MUSHROOM SUBSTRATE PLANT, MULGRAVE APPLICATION TO MODIFY APPROVALS FOR PROJECT AND CONCEPT PLAN (08_0255 MOD 1) RESPONSE TO SUBMISSIONS

FIGURE 2 Existing and Approved Development

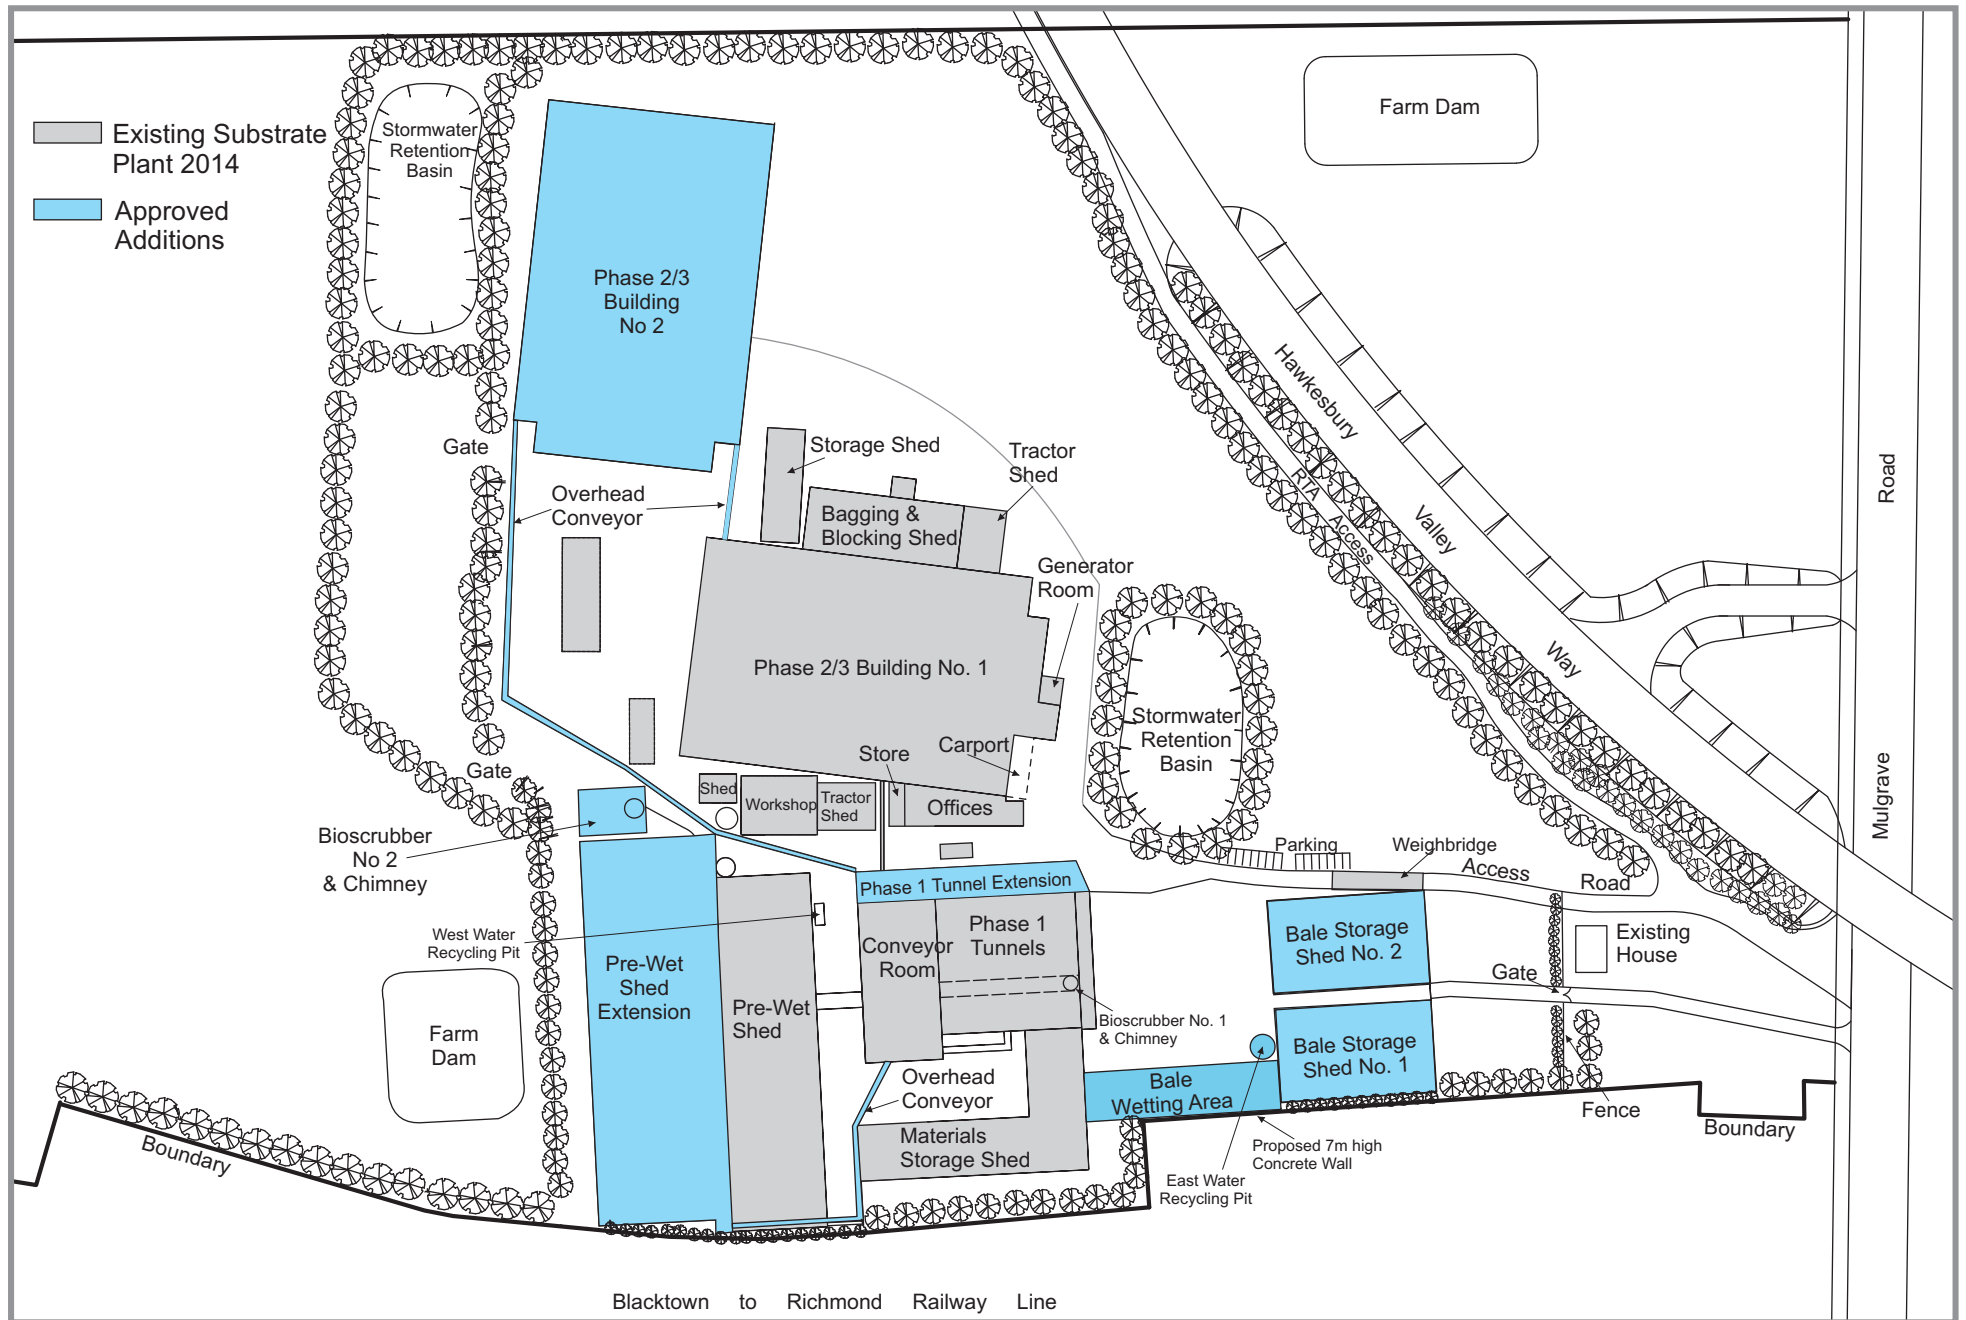
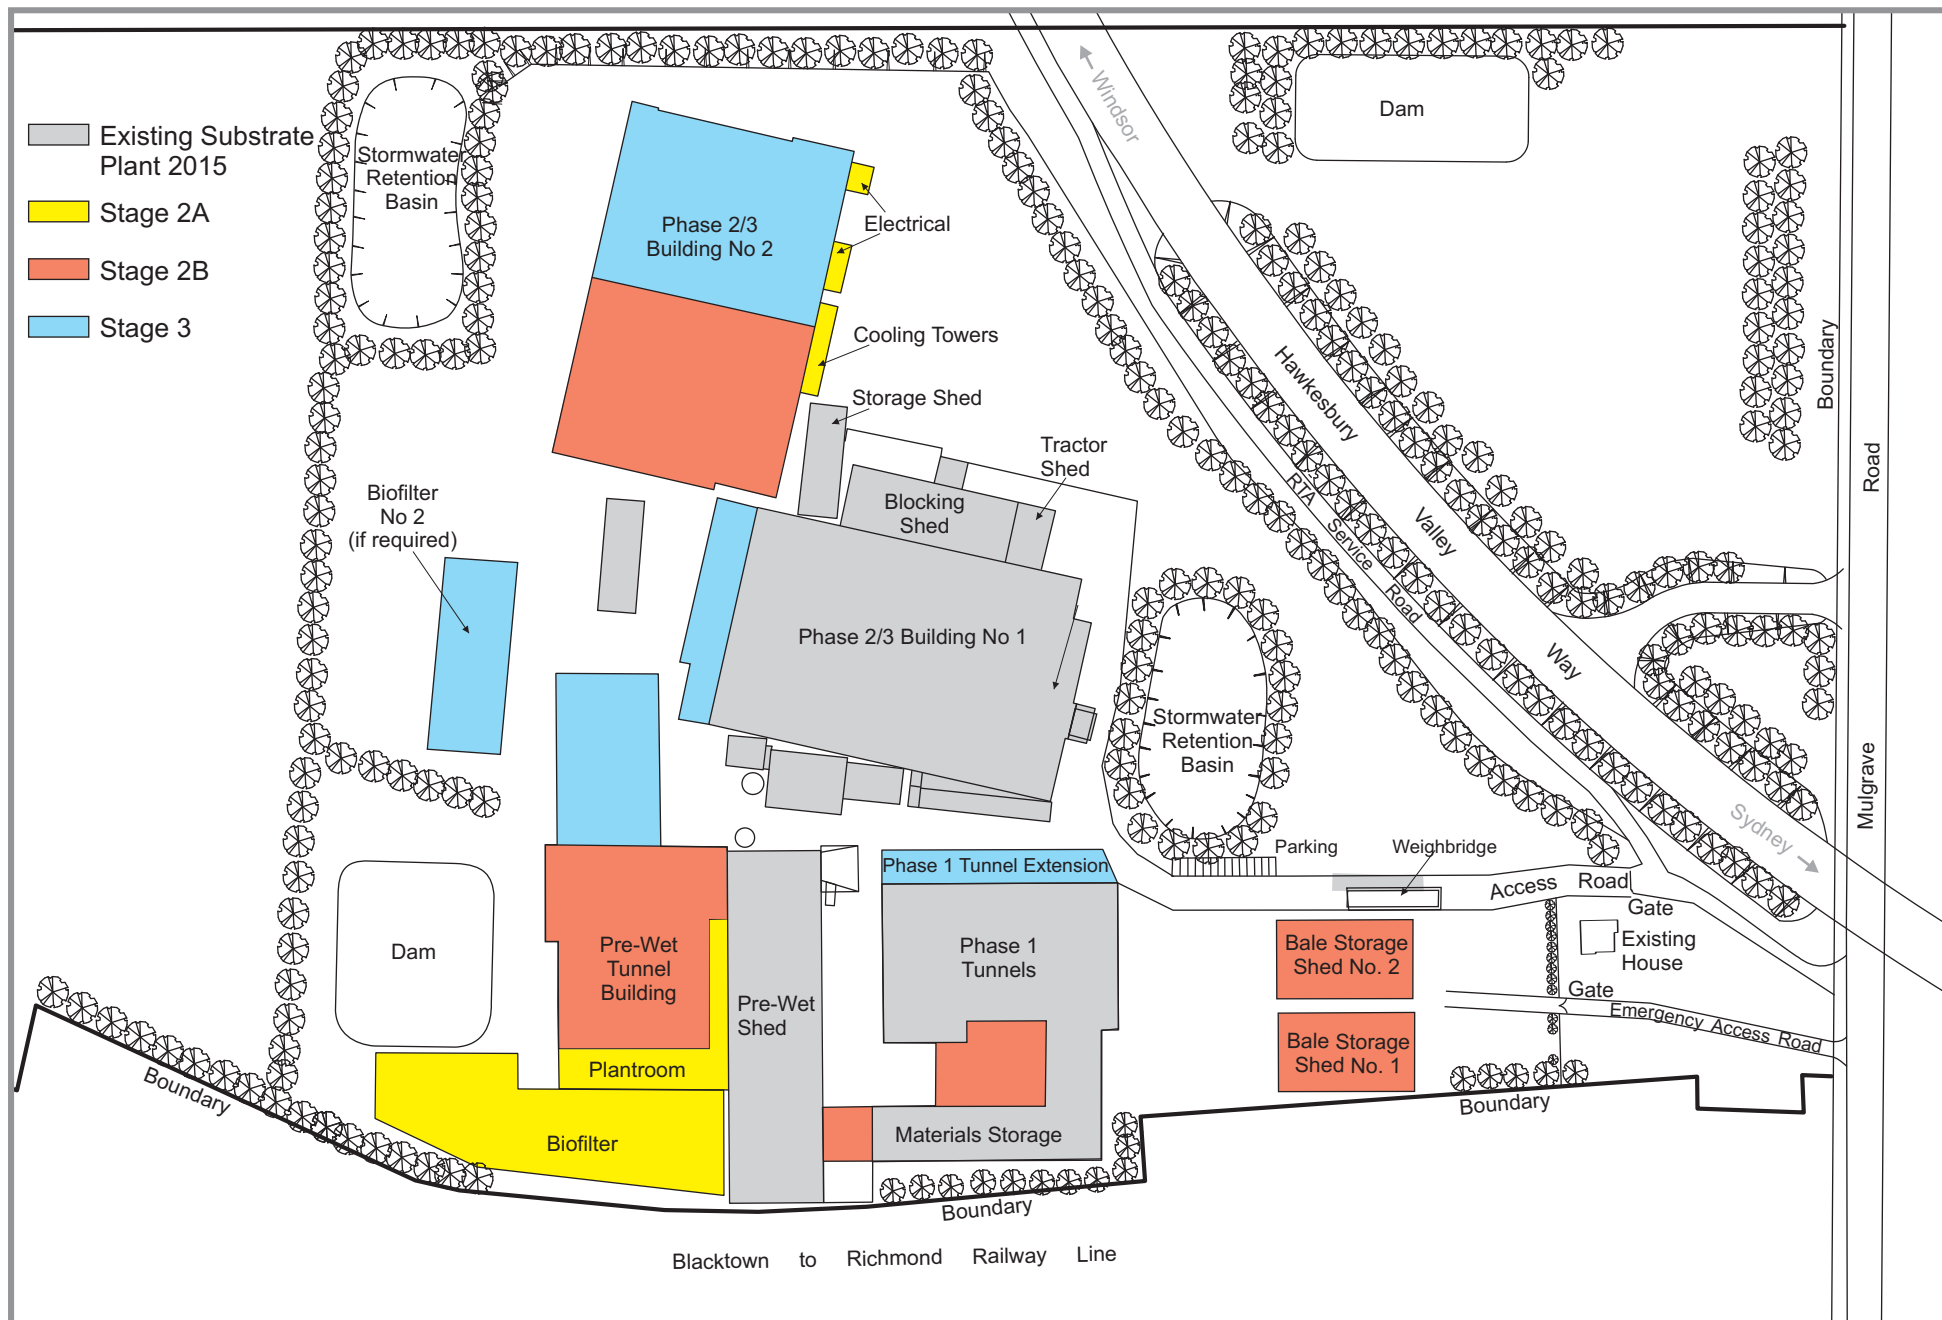
a) Provide more clarity of the approved proposal as modified.

The proposal as modified includes changes to built form and operation. To clarify the building changes, attention is firstly drawn to Figure 2 of the EA, showing the existing plant and in a different colour, structures currently approved but not constructed. This figure should be compared with Figure 6 of the EA, which again shows the existing plant, but this time with the modified structures. In this latter figure the unbuilt structures are shown in various colours according to the intended stage of construction.
